Re: FFCU Office Building
4910 Union Way Dr. NE, 87107
Traffic Circulation Layout
Engineer's/Architect's Stamp 11-8-19 (F16D015A)

Based upon the information provided in your submittal received 11-26-19, the above referenced plan cannot be approved for Building Permit until the following comments are addressed:

E4 BICYCLE RACK

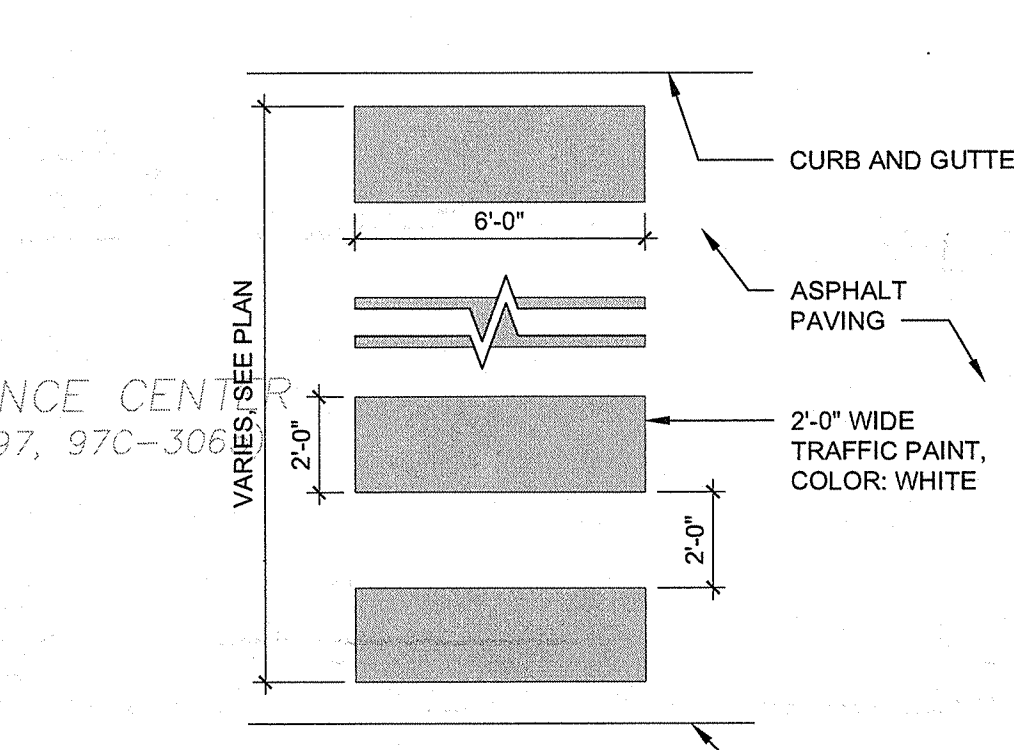
6. 8 foot drive lane at drive up service area not allowed not allowed. (10 foot min.)
7. Add bike rack detail add keynote for location of bike rack on plan.

B5 TRAFFIC SIGNAGE

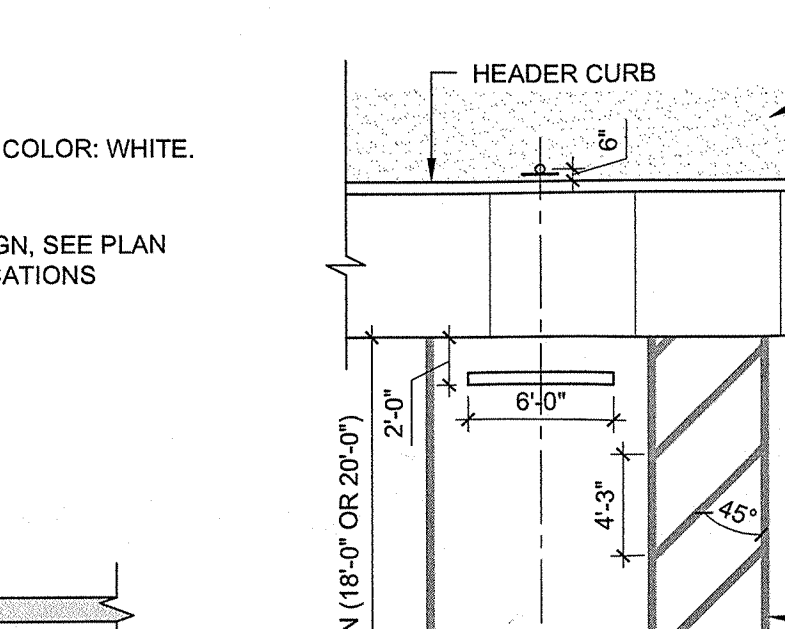
1. Service vehicle and/or refuse vehicle maneuvering must be contained on-site; provide a copy of refuse approval.
2. One-way vehicular paths require pavement directional signage and a posted **"Do Not Enter"** sign at the point of egress. Please show detail and location of posted signs.

B1 SITE PLAN

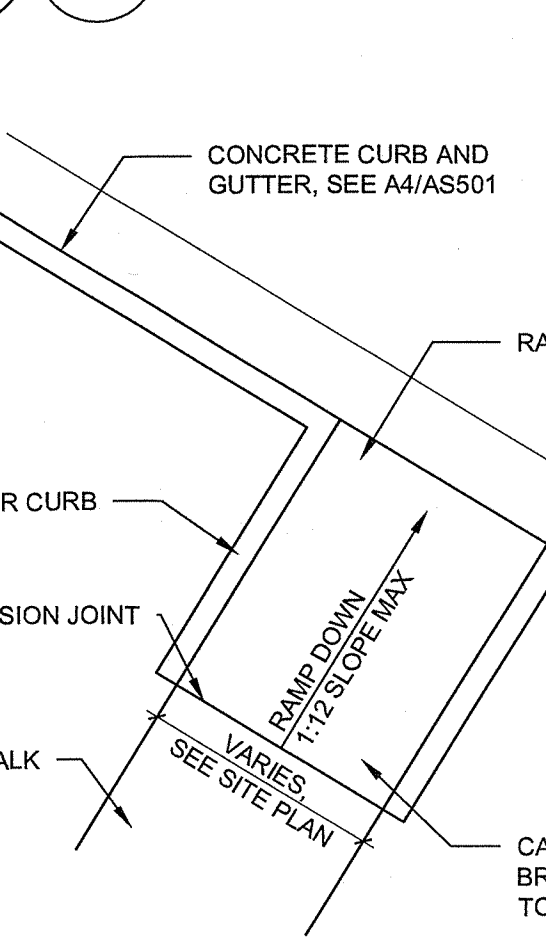
3. (Please add note.) Show the clear sight triangle and add the following note to the plan: "Landscaping and signage will not interfere with clear sight requirements. Therefore, signs, walls, trees, and shrubbery between 3 and 8 feet tall (as measured from the gutter pan) will not be acceptable in the clear sight triangle."
